**Re: State Significant Development Application SSD-58591961 - Building 2 Advanced
Manufacturing Research Facility**

Liverpool City Council was invited to provide comments on State Significant Development Application SSD-58591961 for the development of Building 2 Advanced Manufacturing Research Facility.

Attachment A – Detailed comments

2 WEST ELEVATION
SCALE: 1 : 200

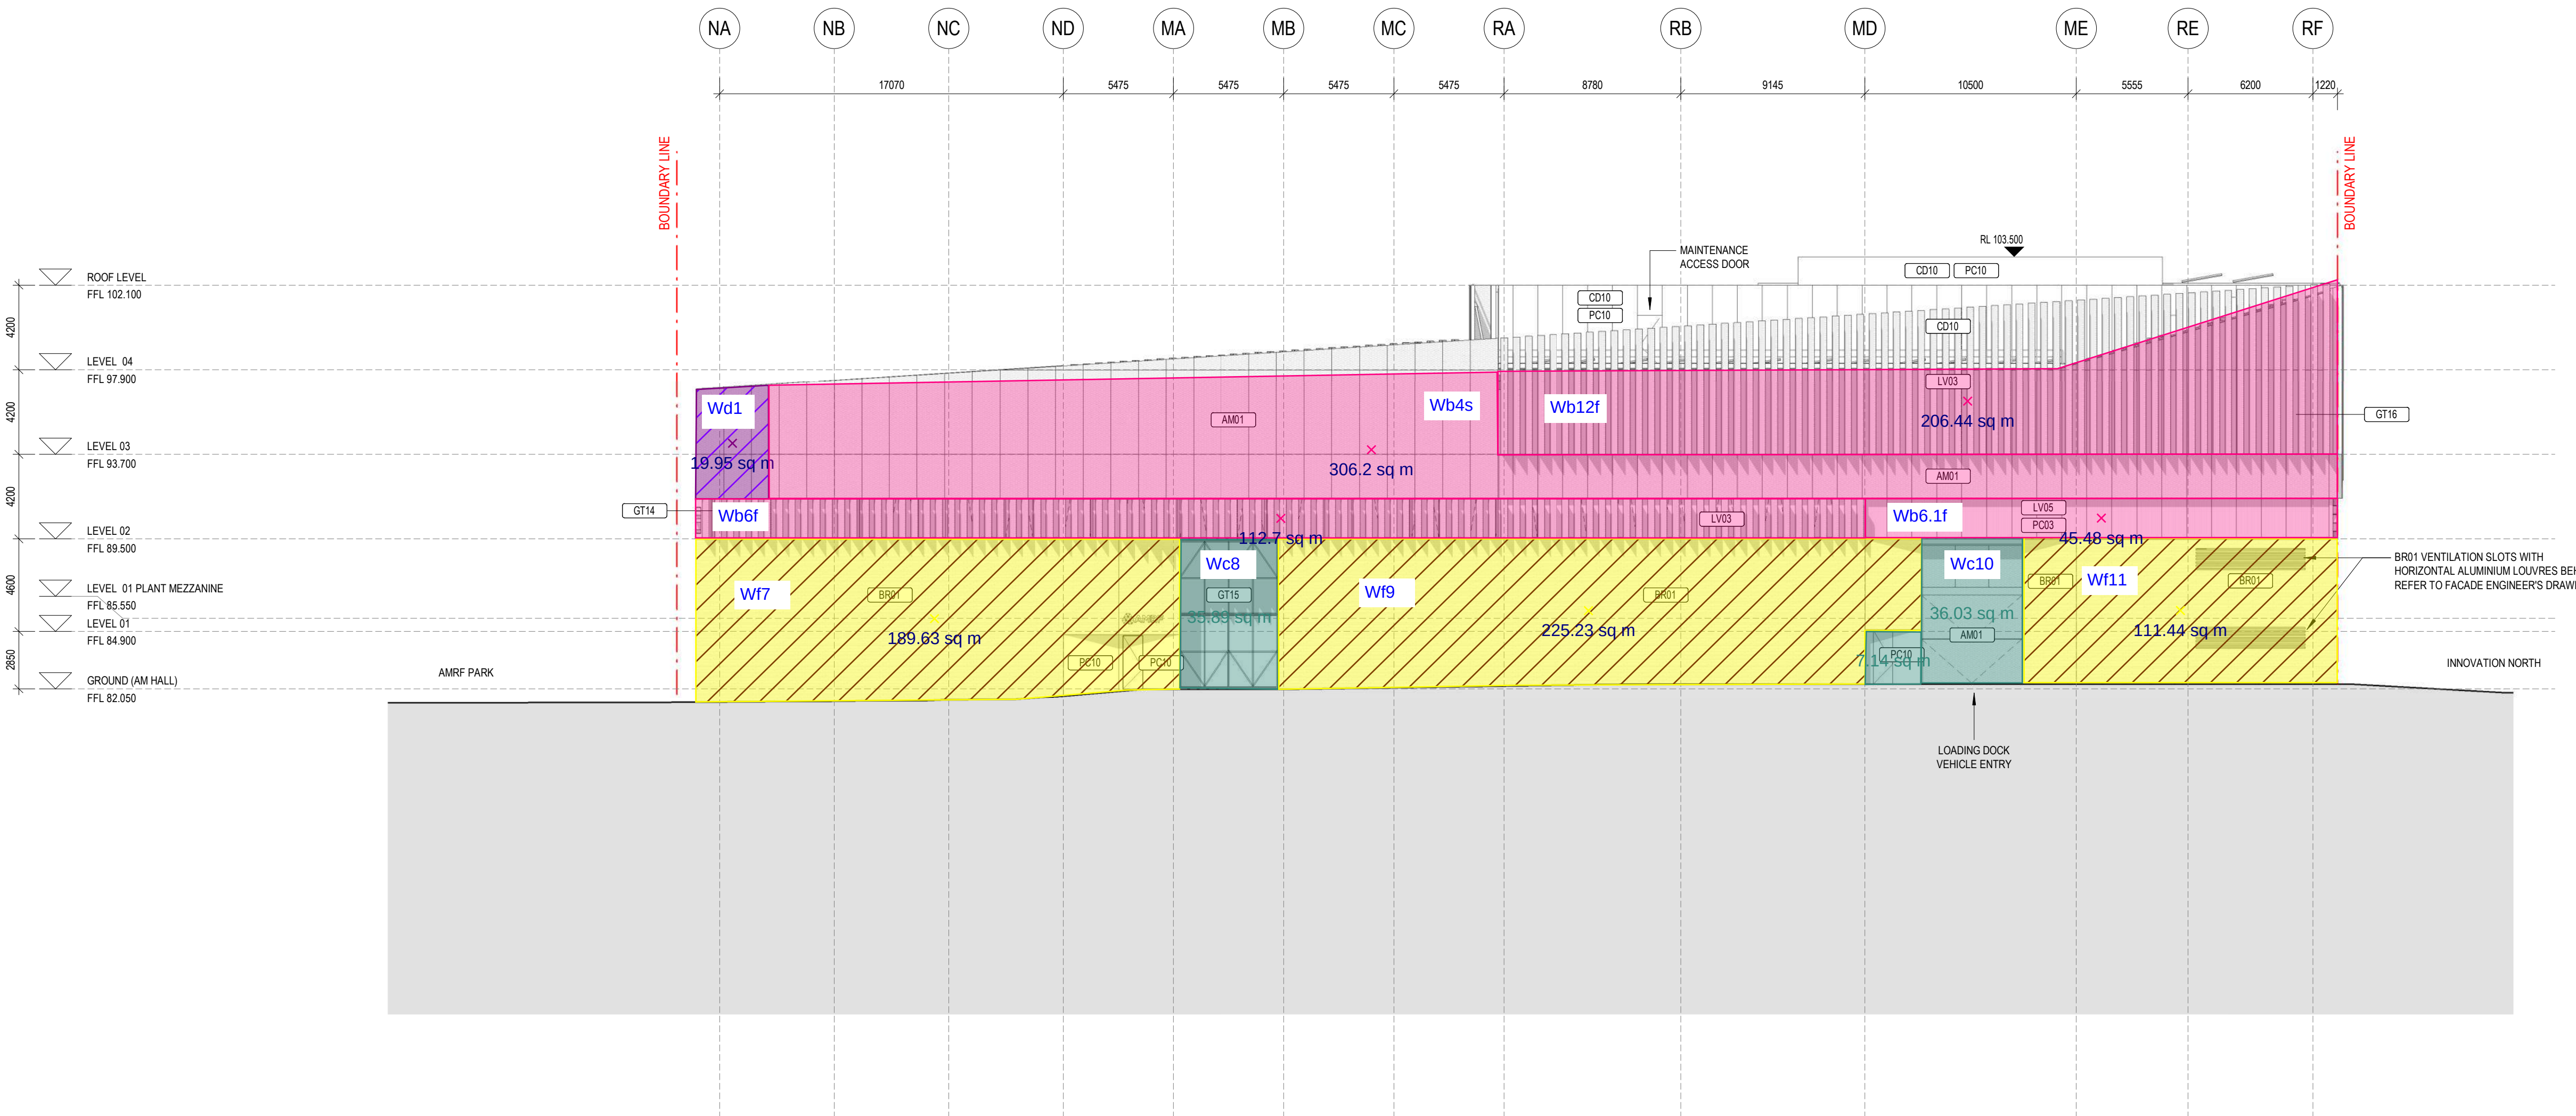
In particular, the Central Loop West façade shows long expanses of blank façade, when it is intended to be a prominent street for pedestrian activity. Council recommends more consideration of passive surveillance and transparency of the building to the public domain that interfaces with the street.

**Figure 6 |** Basement 1 Layout Plan

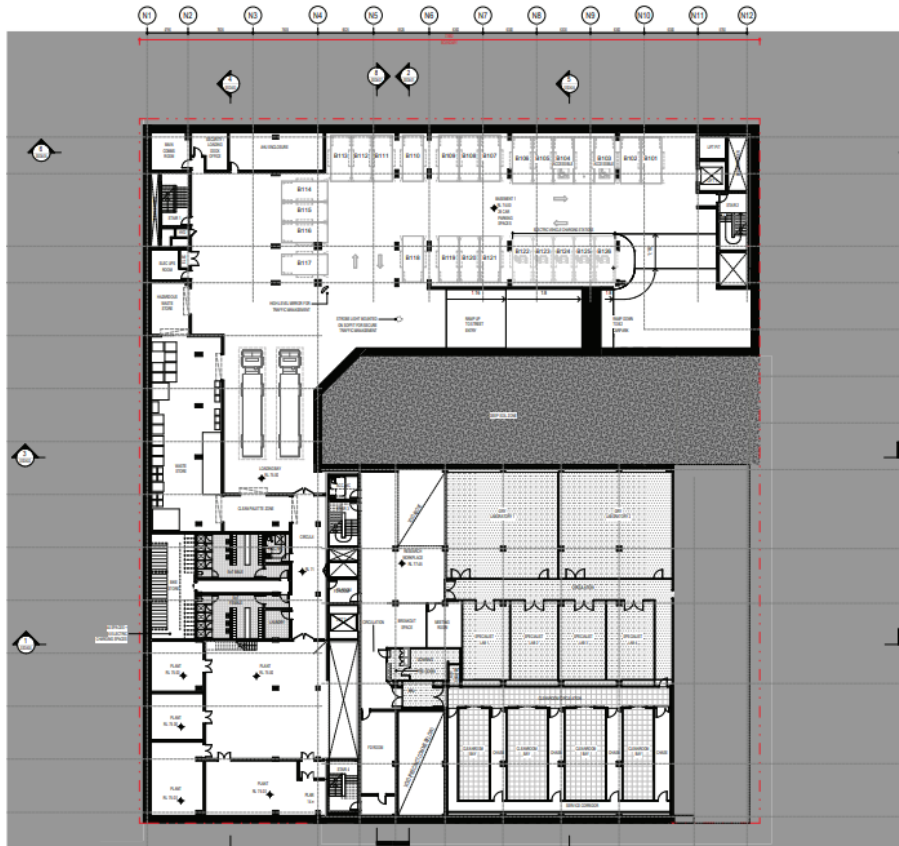
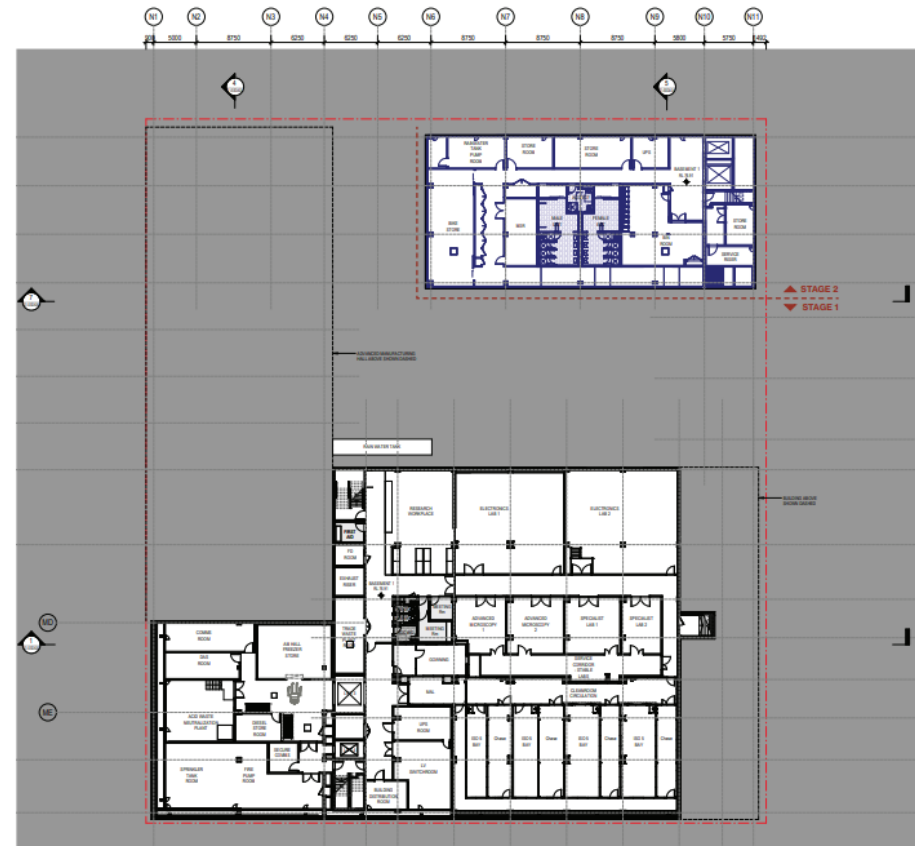
3.9 The basement design is to be supported by turning templates that demonstrate that all vehicles are capable of entering and exiting the basement in a forward direction. Specifically the rigid vehicles included in the Basement Level 1 loading area must be demonstrated to be capable of entering and exiting the basement in a forward direction. If the current design does not permit vehicles to enter and exit the site in a forward direction, it is recommended that the basement parking design is amended to comply with this requirement.

- 4.4.2 The bicycle parking and end of trip facilities are all located in the basement and appear to be accessed via lift 3 only. Council encourages the applicant to provide an alternate mode of access without relying on a lift. If this is to be provided via the driveway, a separate cycle path should be provided entering the driveway and to the bicycle parking, enabling safety from cyclists and entering vehicles.
